Gatwick Northern Runway TR020005

PRINCIPAL AREAS OF DISAGREEMENT SUMMARY STATEMENT – DEADLINE 2 UPDATE

March 2024

Project Code-Location-Discipline-Volume-Type-Unique Number
41700- XX -B -LLO - GA - 200175

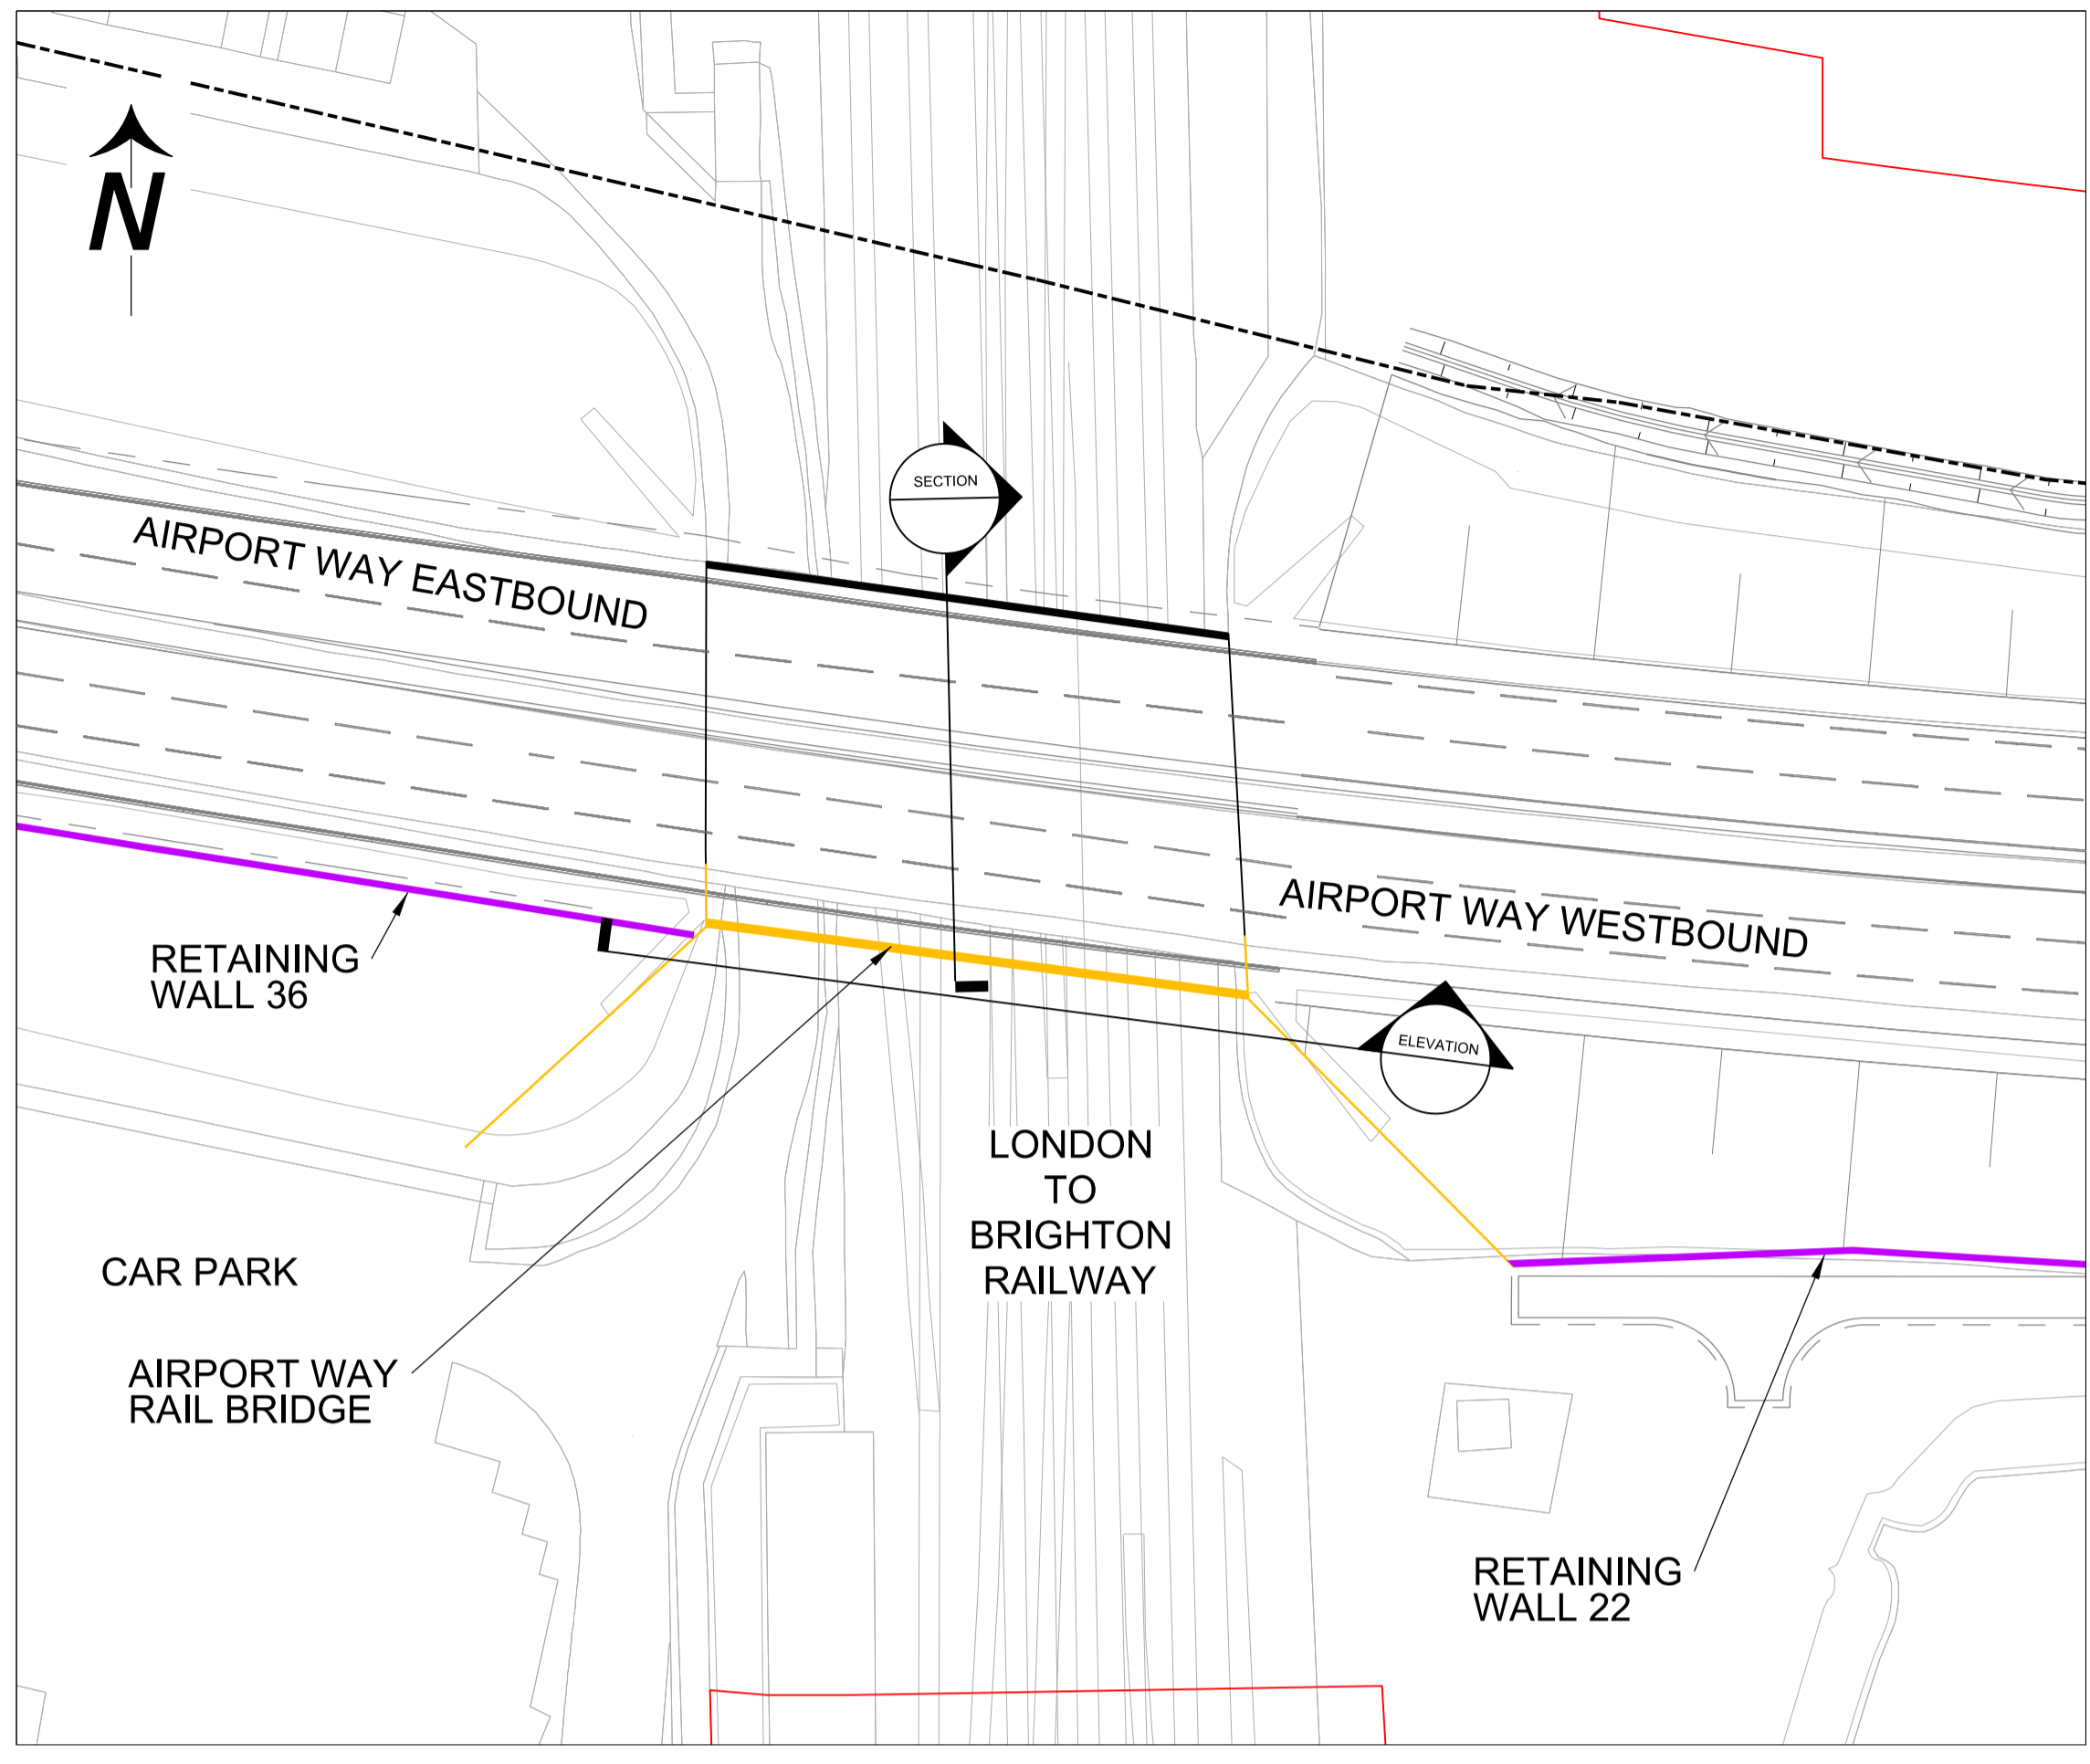
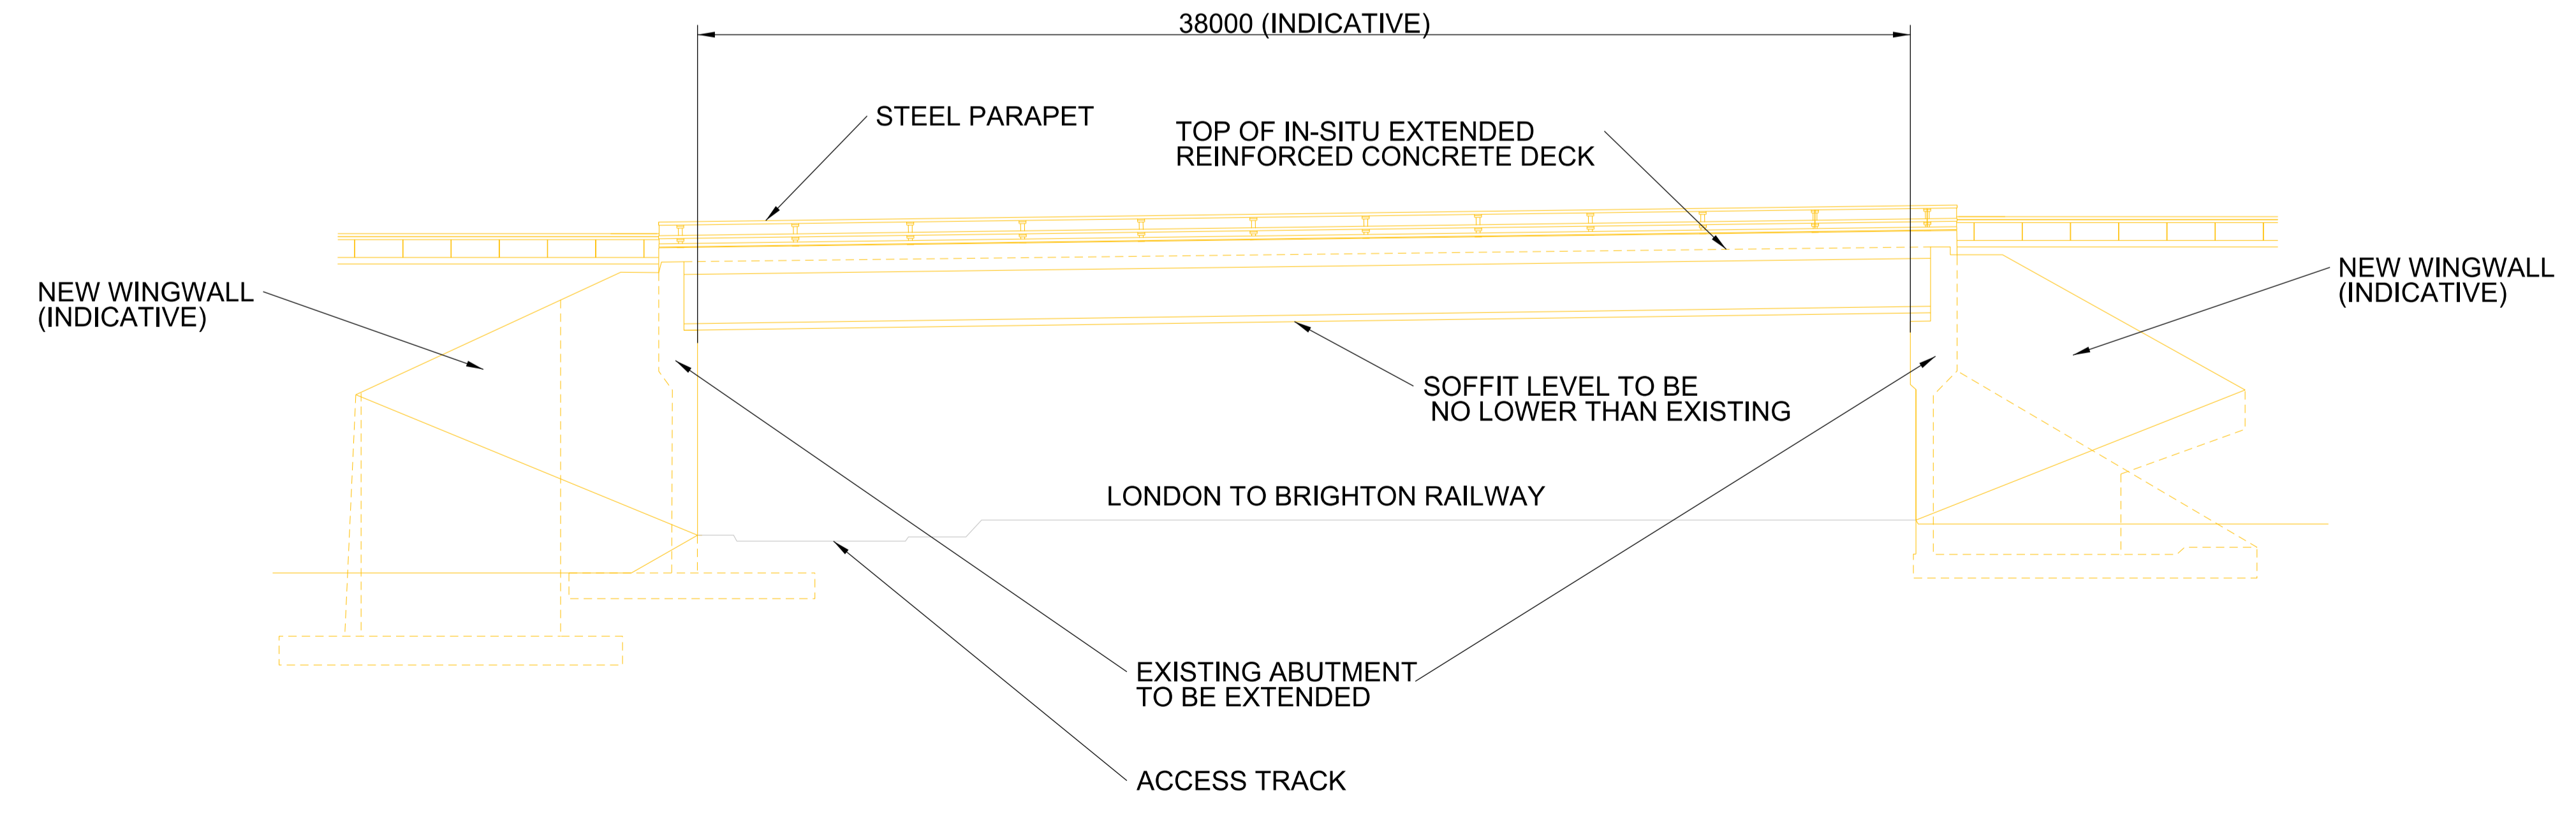
<p><u>37</u></p> <p><u>2.20.5.7</u></p>	<p>Structure Section Drawings (TR020005/APP/022)</p> <p>Drawing 41700-XX-B-LLO-GA-200175</p>	<p>This drawing provides a section; however, the section does not indicate there being any structural parapet on the north side of the noise barrier.</p>	<p>The Applicant is to confirm whether there is edge restraint being provided on this area and, if required, ensure that this drawing is updated.</p> <p>Updated position (Deadline 2): <u>National Highways has reviewed the proposals by the Applicant and recommends the Applicant considers the following two options:</u></p> <p><u>If maintenance activities require operatives to access to the rear of the noise barrier, a pedestrian parapet system is to be installed on the structure to act as an edge restraint to minimise the risk of falling.</u></p> <p><u>If there are no maintenance activities required to the rear of the noise barrier, the noise barrier is to be repositioned on the structure to sit on the plinth, thereby restricting any unauthorised access to the structure. If this solution is considered by the Applicant, the relocation of the noise barrier may need to be considered as part of any acoustic assessments.</u></p>	<p>High</p>
